KIRKLEES METROPOLITAN COUNCIL INVESTMENT & REGENERATION SERVICE

DELEGATED DECISION TO DETERMINE PLANNING APPLICATIONS

Reference No:	2025/62/92730/W
Site Address:	9, Regent Road, Kirkheaton, Huddersfield, HD5 0LW
Description:	Erection of extension to extend accommodation in first floor and basement
Recommending Officer:	Jennifer Booth

CLIENT			
ELOISE HALL			
PROJECT			
PROPOSED EXTENSION 9 REGENT ROAD KIRKHEATON			
DRAWING TITLE			
PROPOSED ELEVATIONS			
Rev.	Notes	Date	Drawn
A.	PLANNING	11.25	A.D.
SCALE			
1:50 AT A1		09.25	A.D.
PROJECT No.	DRAWING No.	Rev.	
2559	004	A

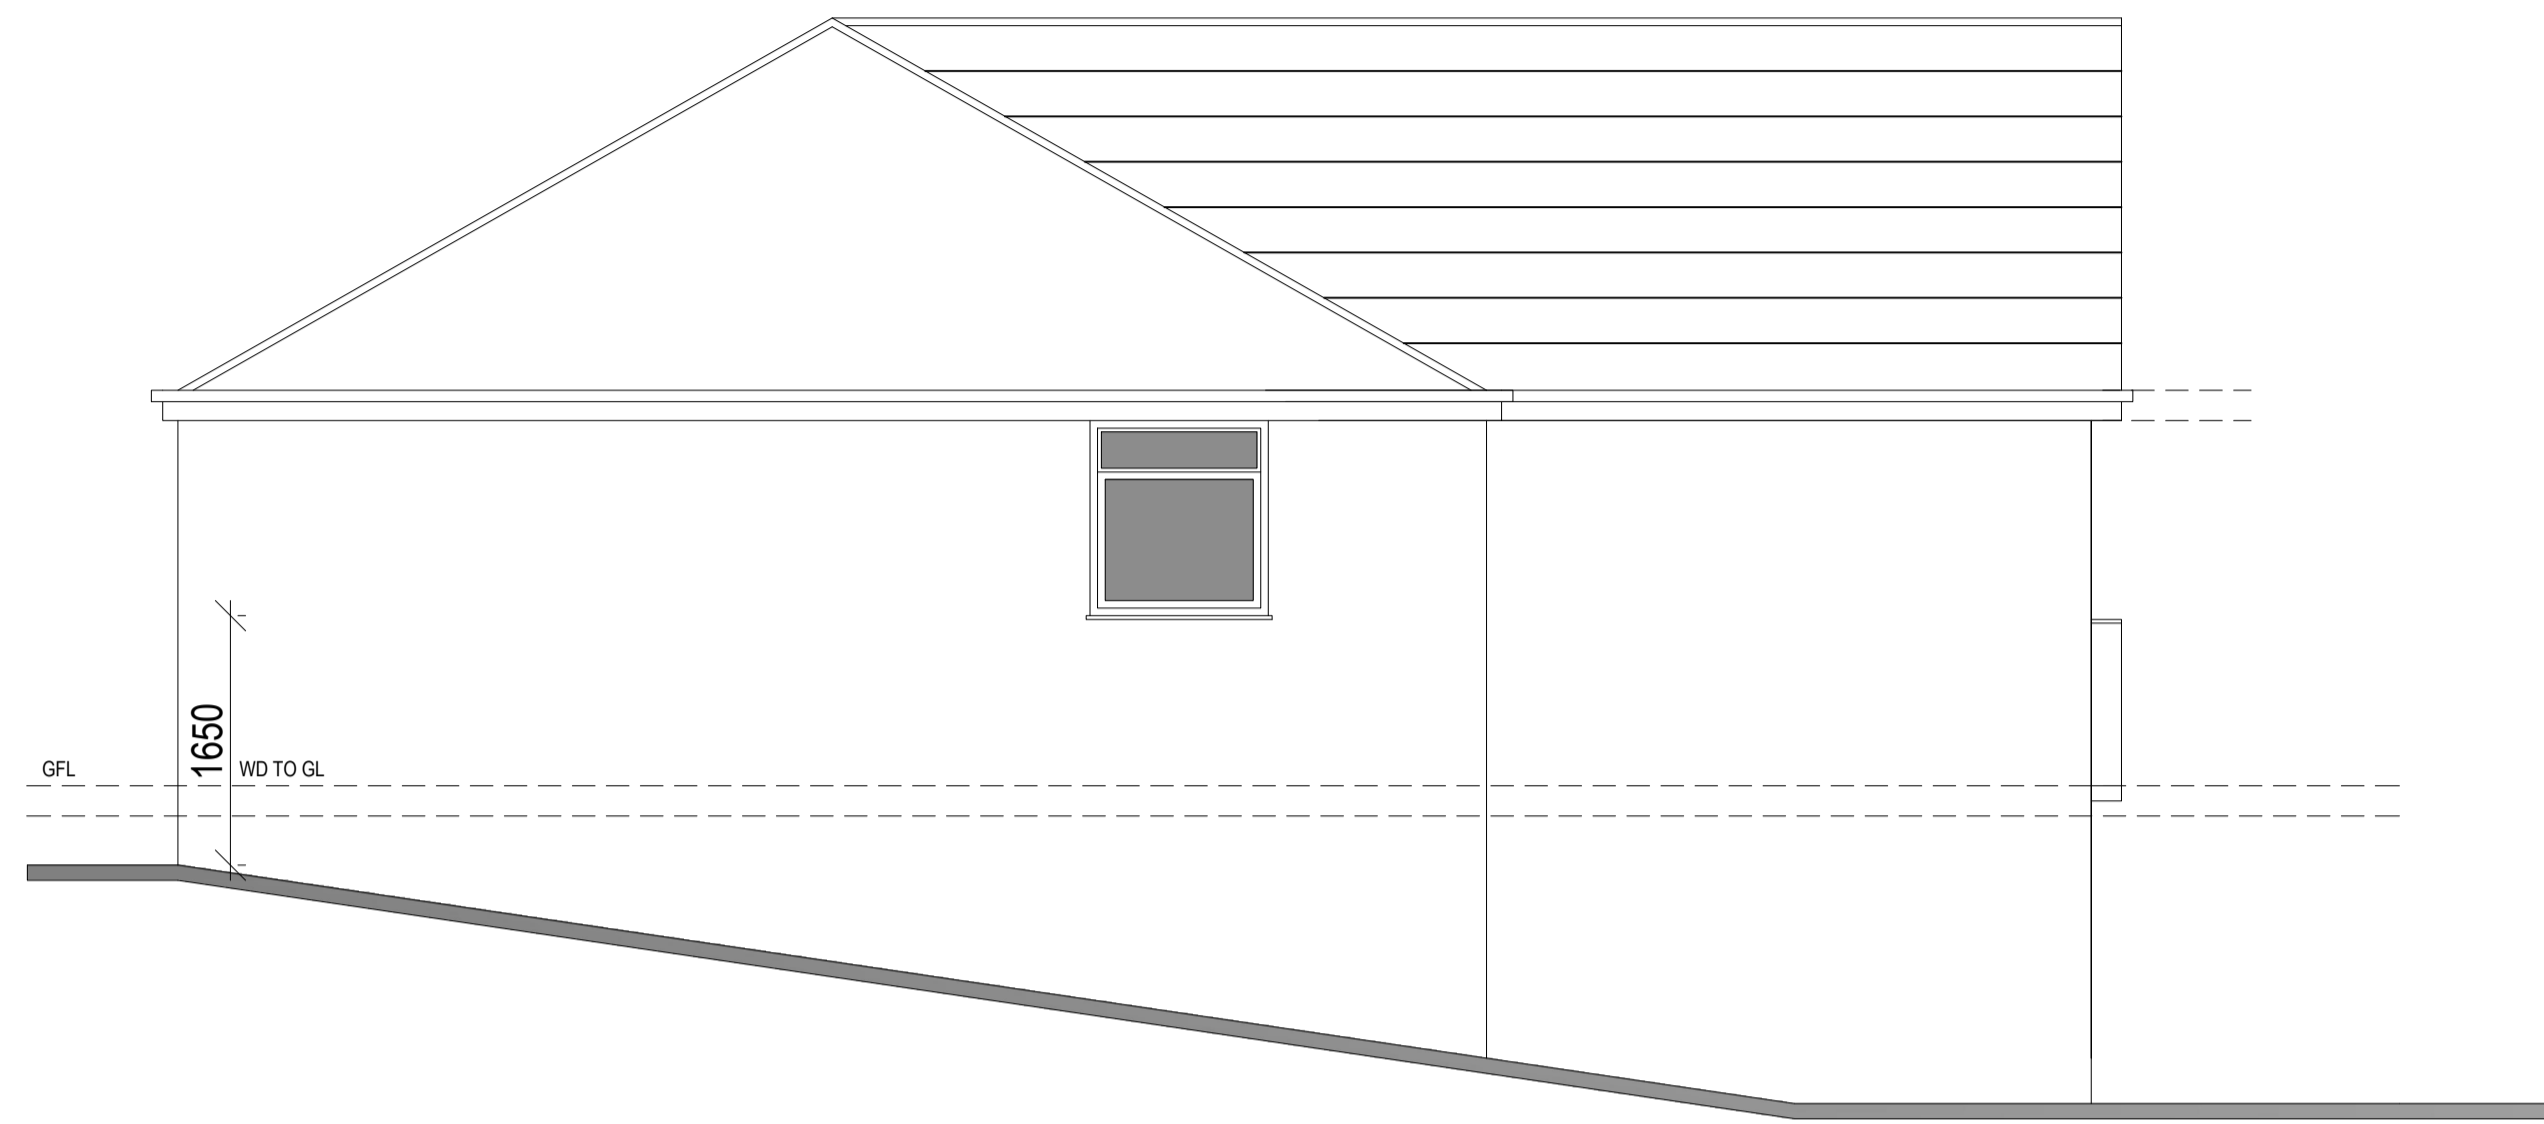
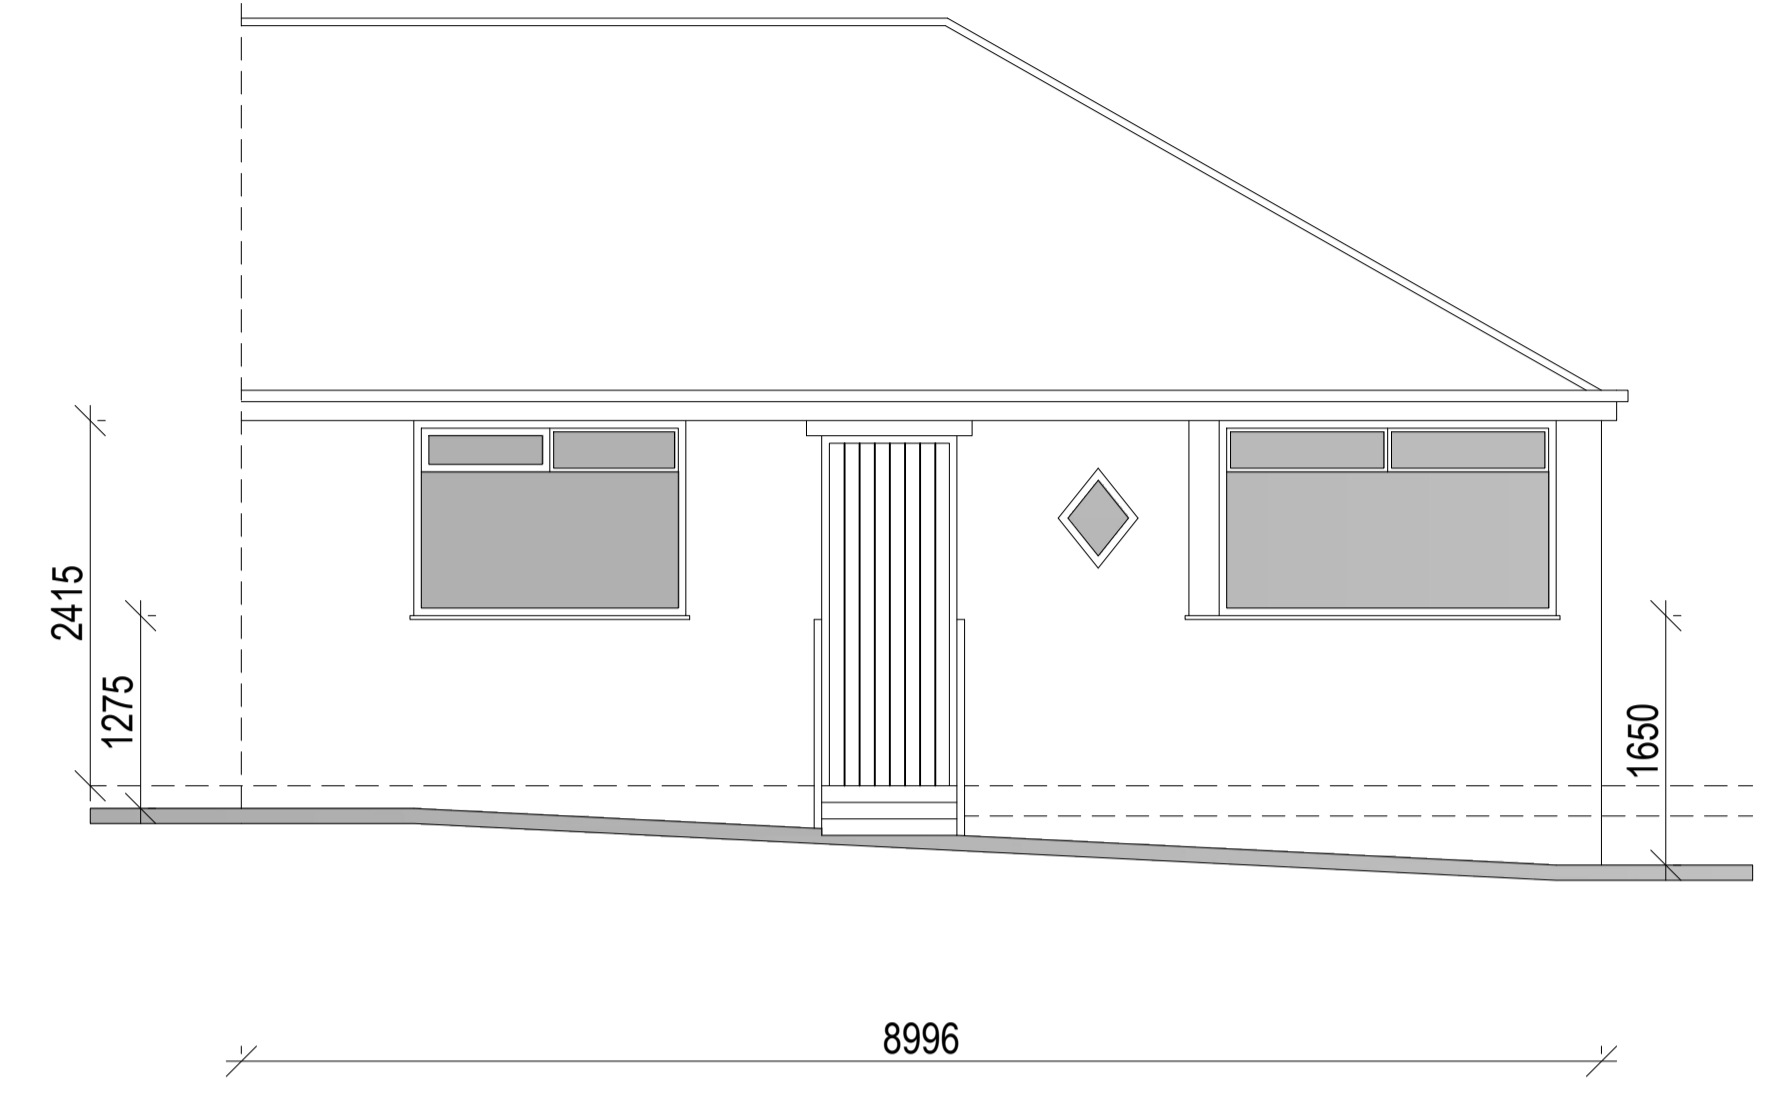
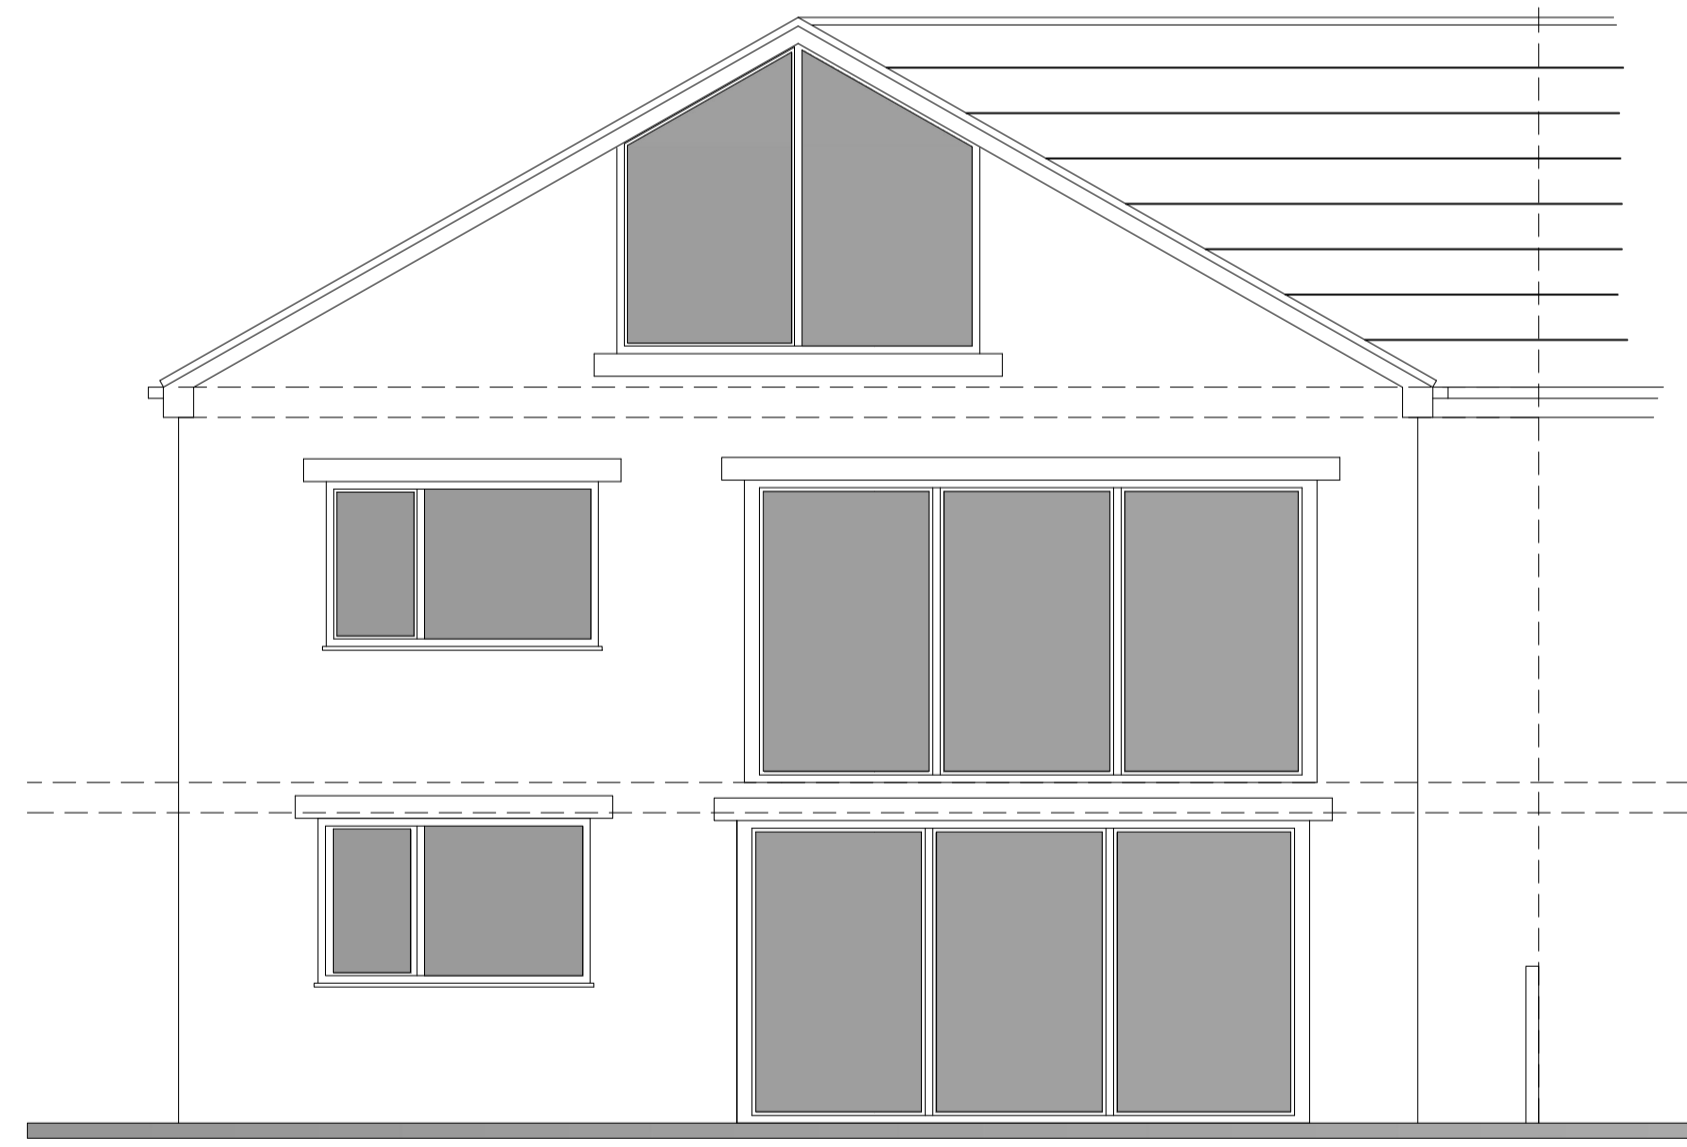
There were issues with the initially submitted plans given the projection proposed and a discrepancy with the elevations. Amended/corrected plans

have been provided which reduced the projection, corrected the discrepancy and showed the 45 degree relationship with the adjoining dwelling. The alterations did not increase the scheme; therefore the amended plans have not been advertised.
